June 15, 2022

**RE: Mojave Ridge Subdivision
6341 Mojave Rd. NW
Grading and Drainage Plan
Engineer's Stamp Date: 05/19/2022
Hydrology File: E10D024**

Based upon the information provided in your submittal received 03/31/2022, the Grading & Drainage Plan **is not** approved for Grading Permit. The following comments need to be addressed for approval of the above referenced project:

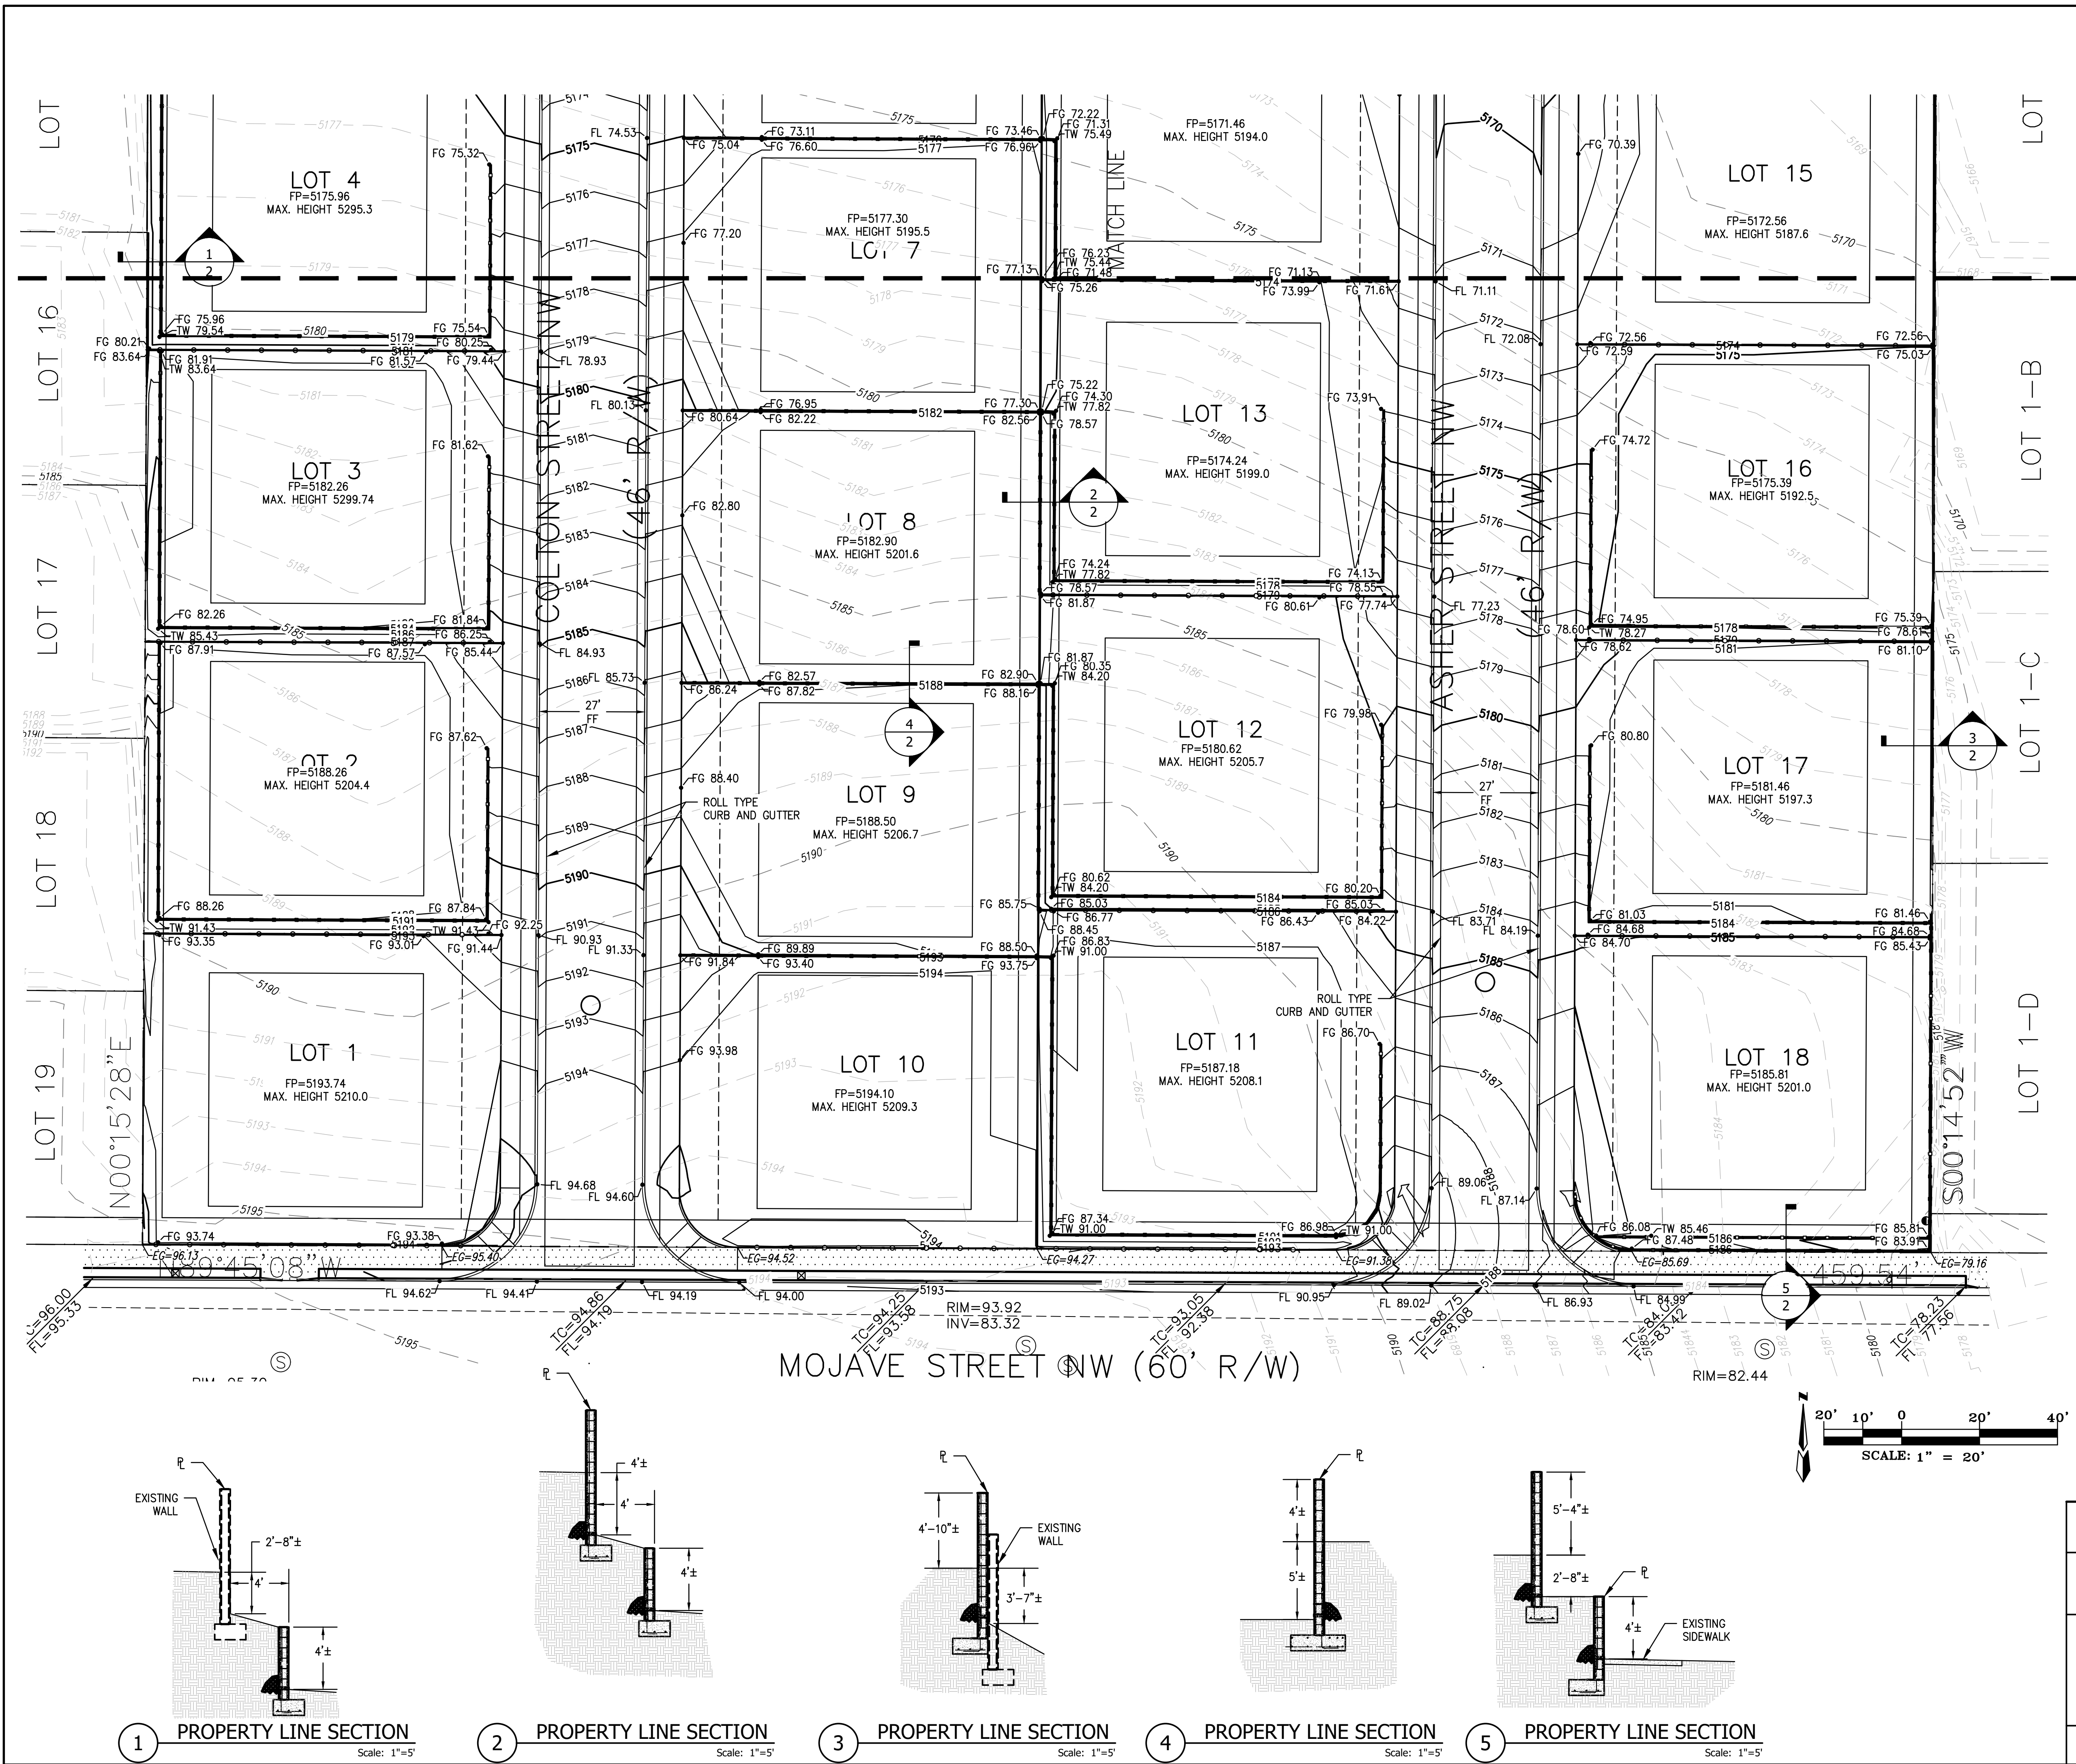
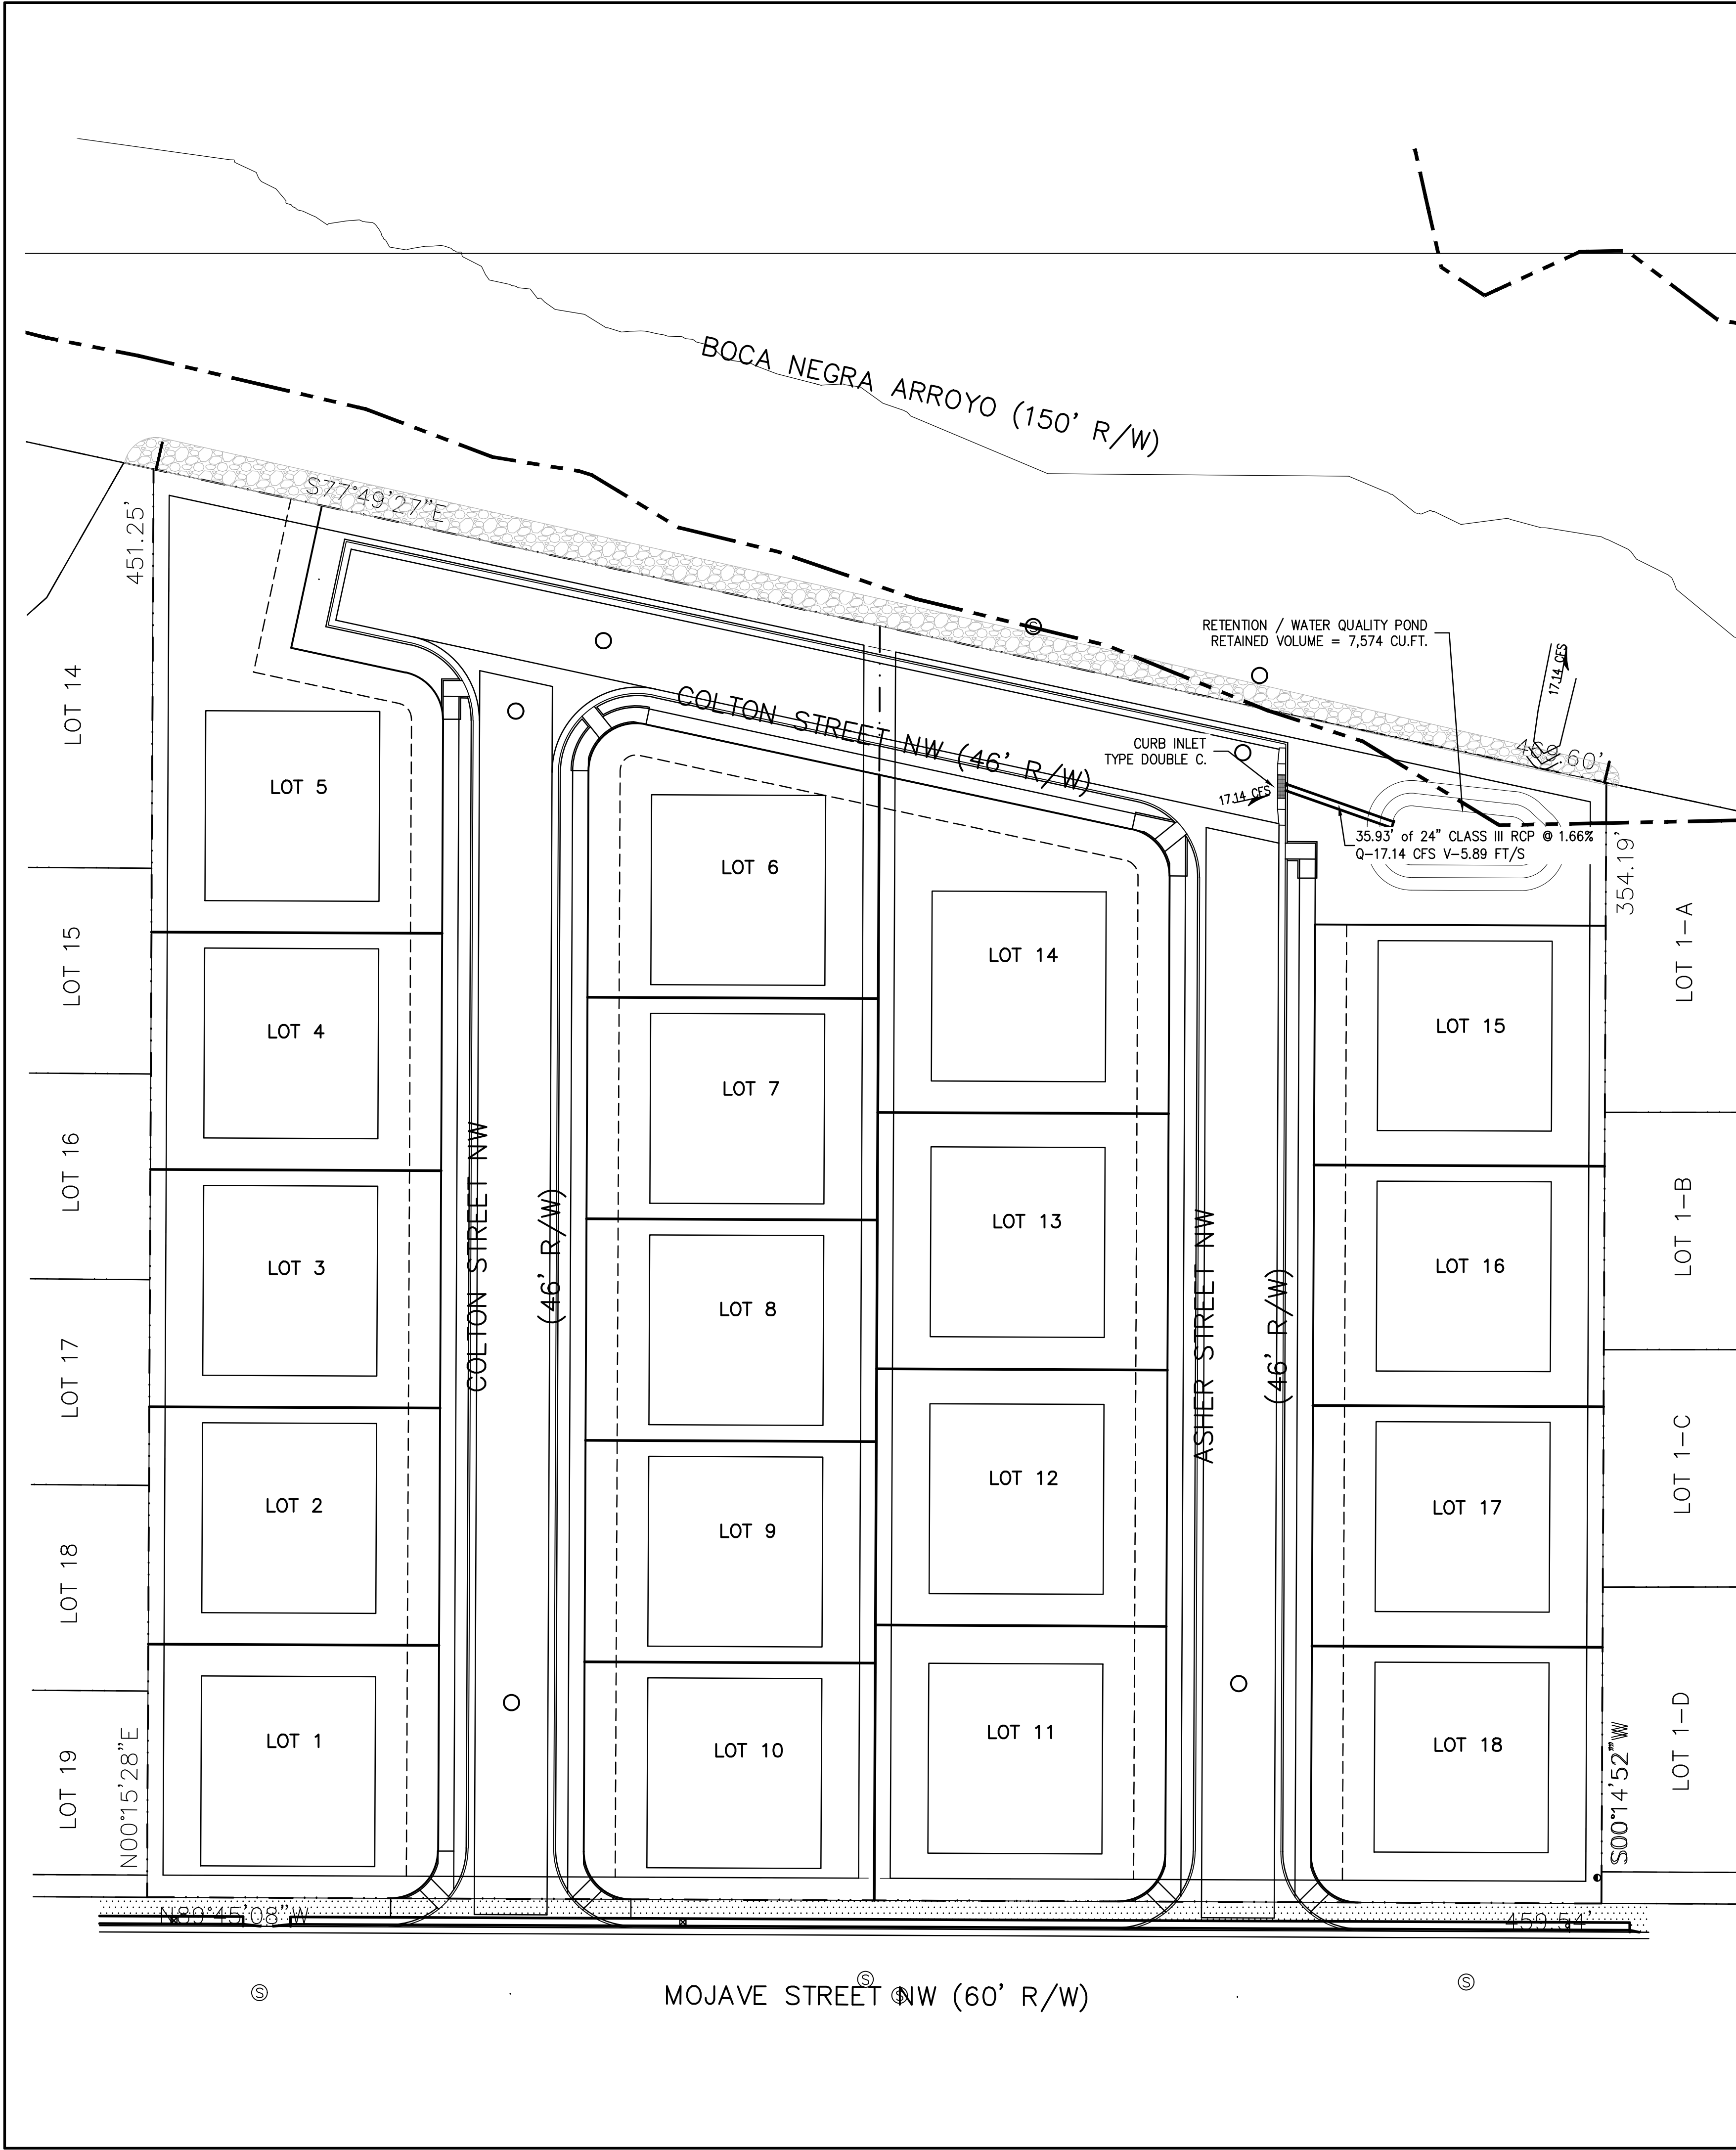
- d. Please include all needed calcs in the report.
2. Please call out slopes and inflection point where it changes (SAG).
3. Please clearly note where curb transitions as well.

4. Provide elevations at each property corner at flowline.
5. The specific curb and gutter needs to be defined. 6"? 8"? Width?
6. I would like to see quarter points so it matches the plans for work order. Please show these points for reference and constructability. Any inlets to be constructed require TC as well. Please review and provide grate elevations, inverts etc...

MOJAVE SUBDIVISION
GRADING AND DRAINAGE
DRAINAGE PLAN

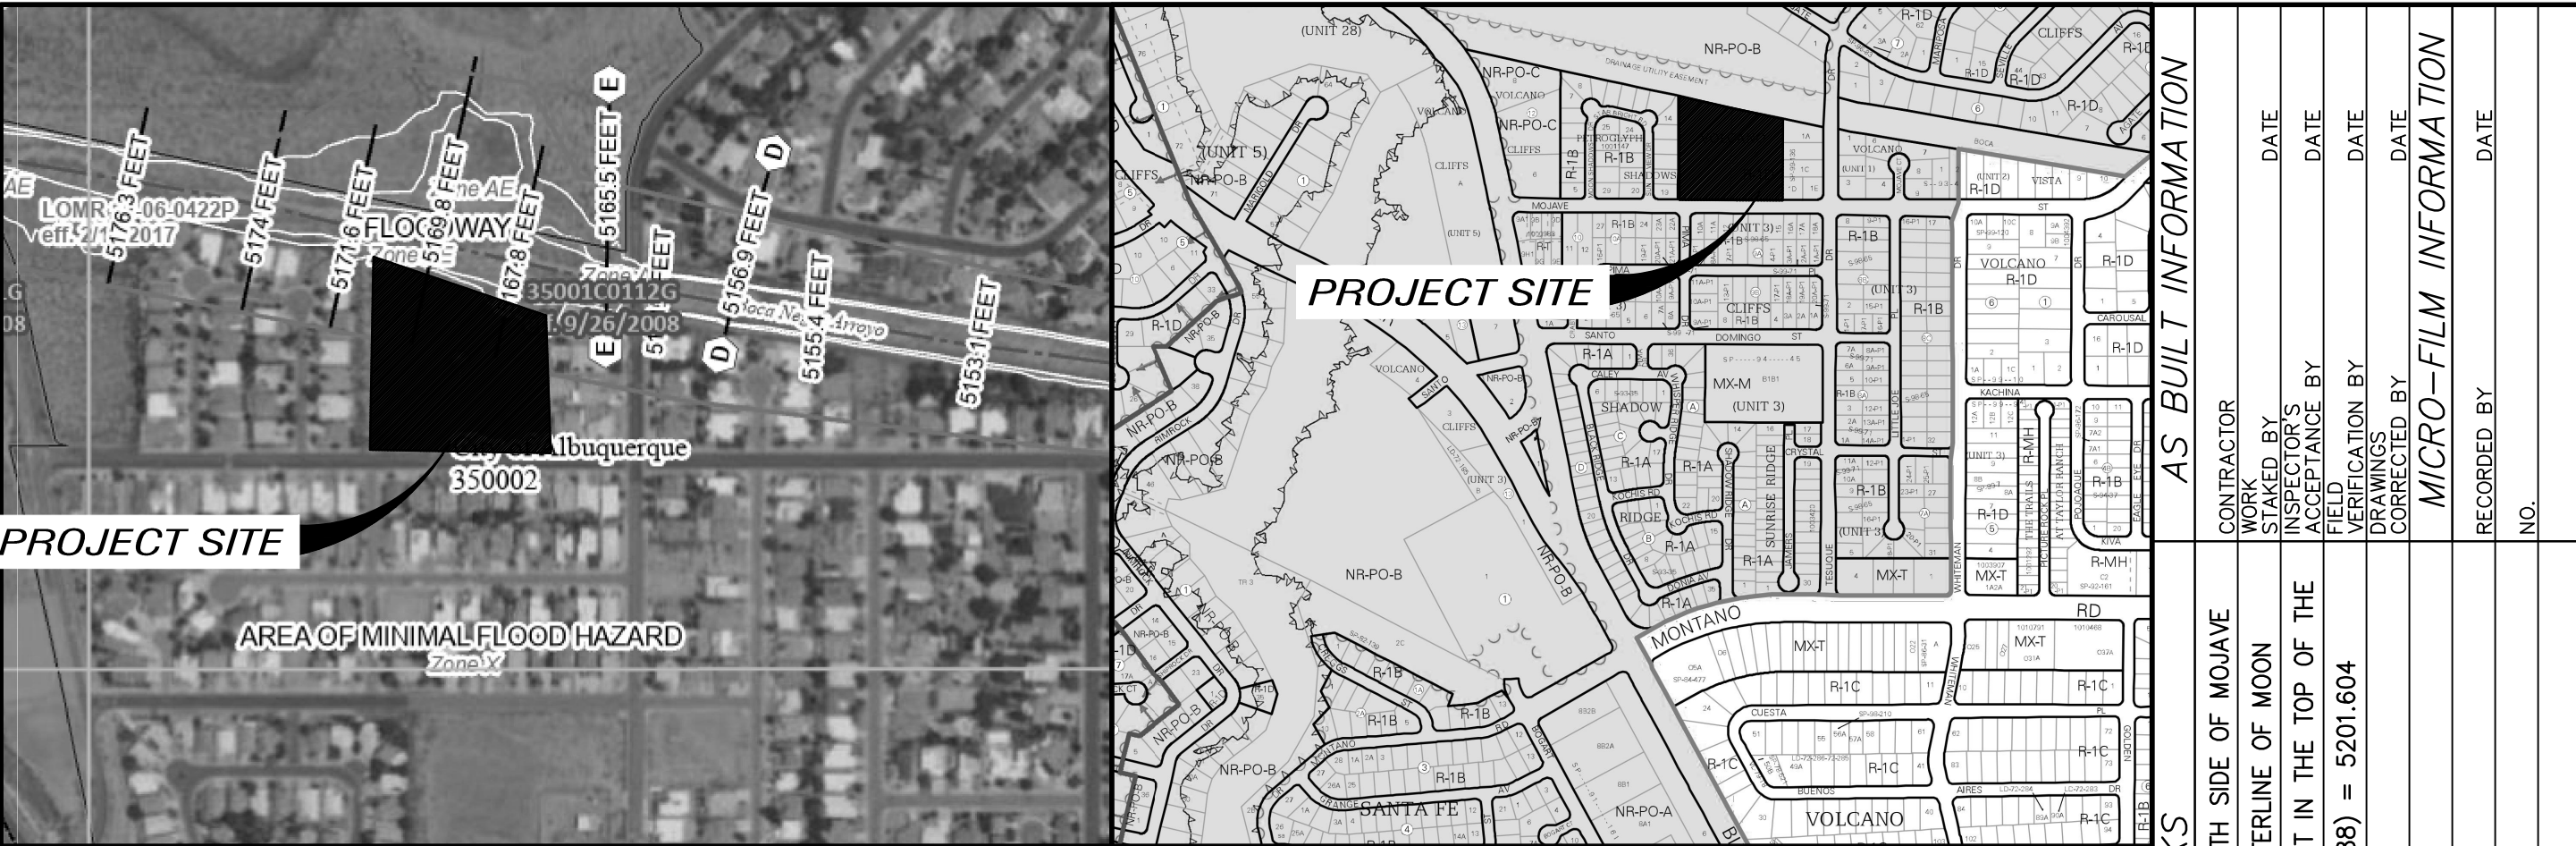
1. Please provide a detailed drainage report including
 - a. Street hydraulic capacity.
 - b. HGL and if needed inlets based on report findings.
 - i. Calcs for inlets and flow going through them. If they are not needed, the report/HGL will dictate based on design with slope changes etc... I want to confirm that we are not sending water overtopping any C&G and potentially causing issues.

- c. LOMR study details and sections (4 sections) that are relating to this project.
 - i. Include calcs based on LOMR in the report. I do not have access to a copy so if you get one, please send it my way for our records. I am going to continue to search for one but as of right now, I have yet to find a copy.
